**KIRKLEES METROPOLITAN COUNCIL
INVESTMENT & REGENERATION SERVICE**

DELEGATED DECISION TO DETERMINE PLANNING APPLICATIONS

Reference No: 2020/62/93334/W
Site Address: 17, Kaye Lane, Almondbury, Huddersfield, HD5 8XP
Description: Erection of first floor balcony over conservatory
Recommending Officer: Sam Jackman

DECISION – CONDITIONAL FULL PERMISSION

Plans & Elevations - As Proposed

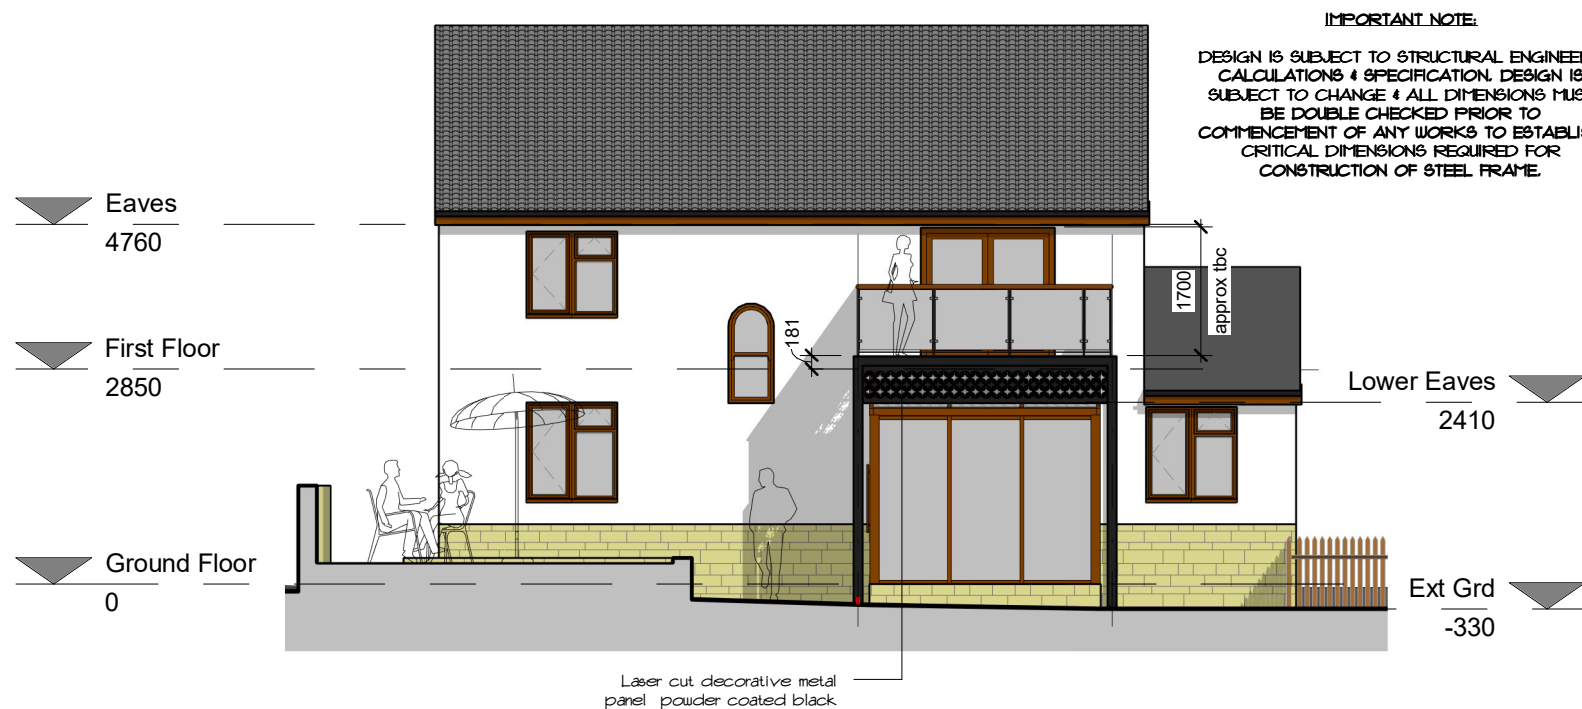
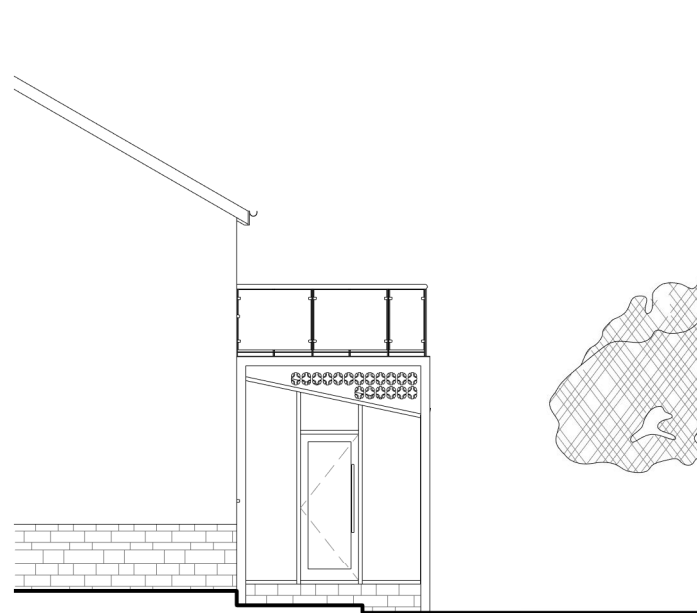
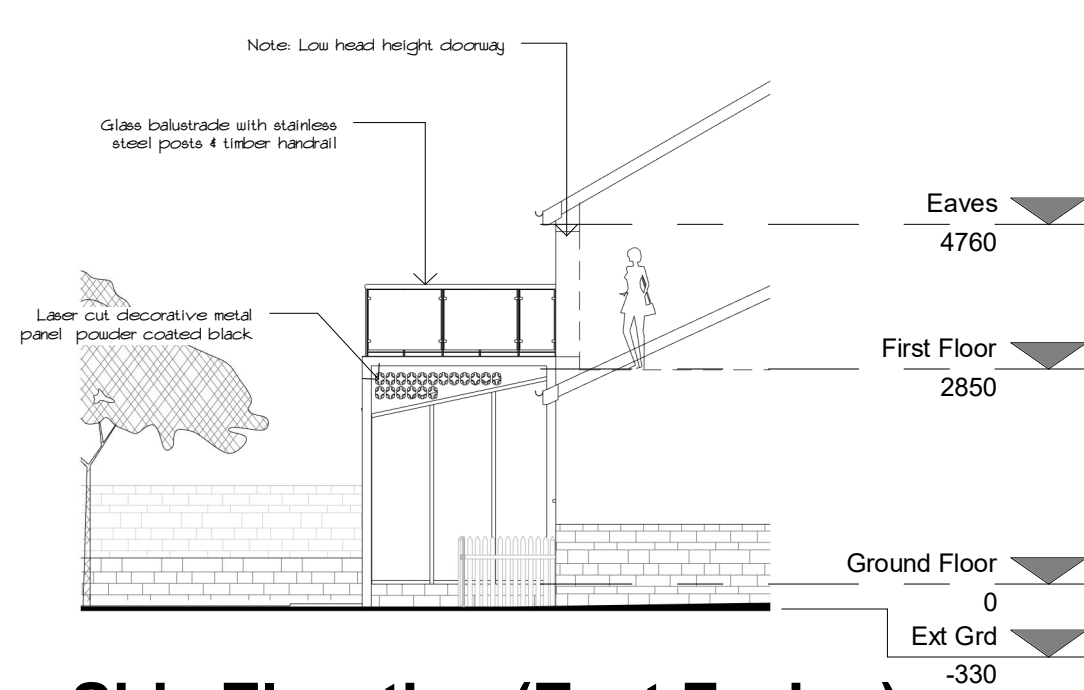
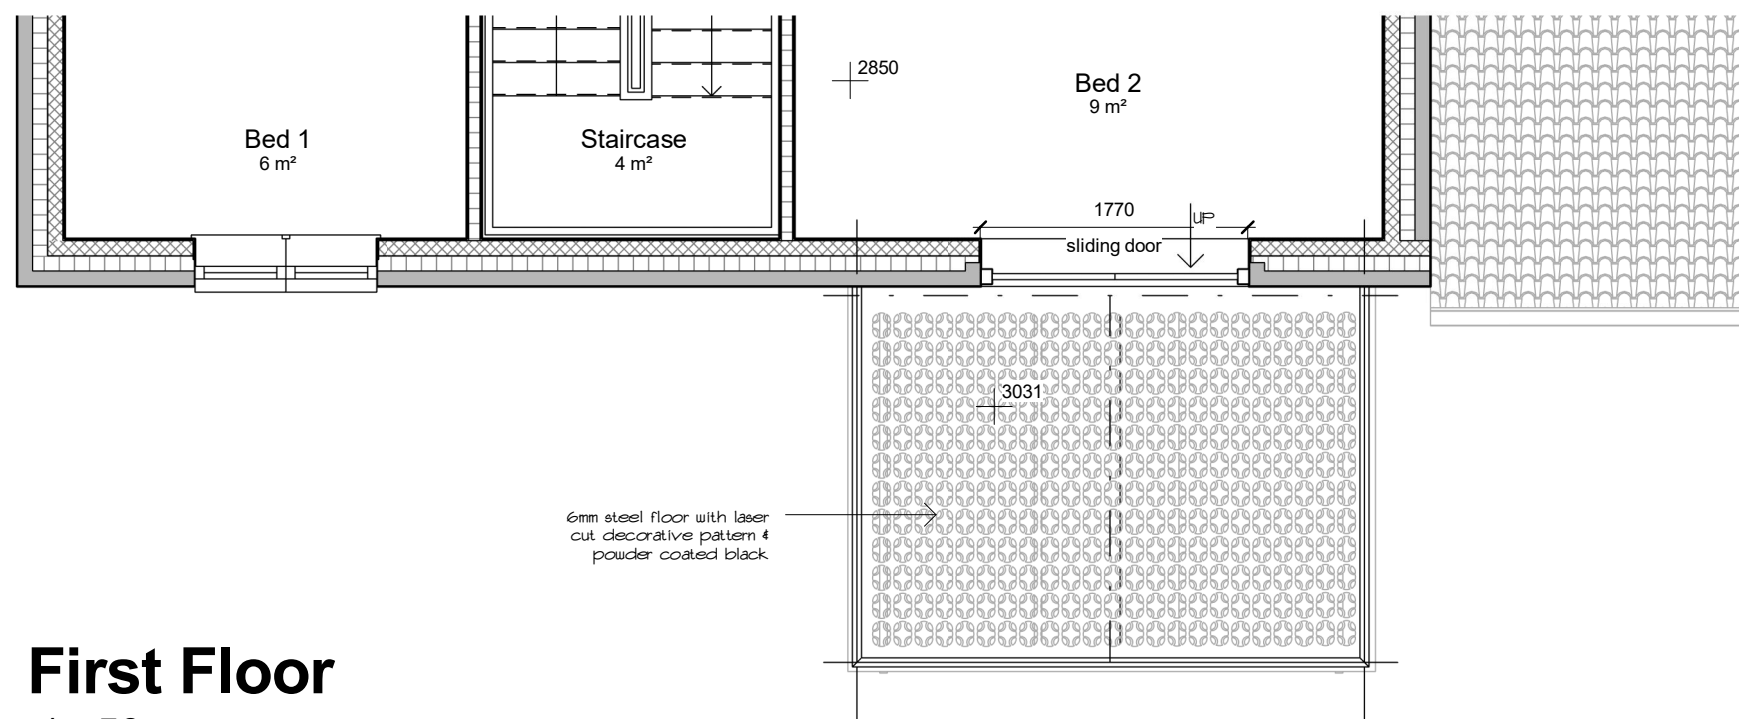
With regards overlooking the neighbour at No 19, which is situated at a higher level of approx. 1.5m than the application site where they have a large garage built on the boundary and boundary wall, providing screening between the two neighbour furthermore there is a separation distance of 7m to the boundary, therefore there would be limited scope for an overlooking impact to occur.

With regards to the neighbour at No 15, where they are at a slightly lower level with a separation distance of approx. 6, they also have a large garage built on the boundary and a single storey rear extension which bridges the gap between the property and garage. This is considered, in part to screen the balcony from the neighbour, however given that the separation distance is less and No. 15 is at a lower level it is considered that an obscure glazed privacy screen would prevent overlooking of the neighbour's property in this case. (condition 3).

3. Notwithstanding the submitted details shown, the balcony hereby approved shall not be brought into use until a glass balustrade measuring 1.68 metres in height from the finished floor level of the balcony on the east facing elevation has been erected. The balustrade shall be constructed from obscure glazing which shall be equivalent to, or more obscure than, Grade 4 privacy

Reason: In the interests of residential amenity, to avoid overlooking or loss of privacy to the adjoining occupiers at 15 Kaye Lane and to accord with Policy LP24 (c) of the Kirklees Local Plan and advice within the National Planning Policy Framework.
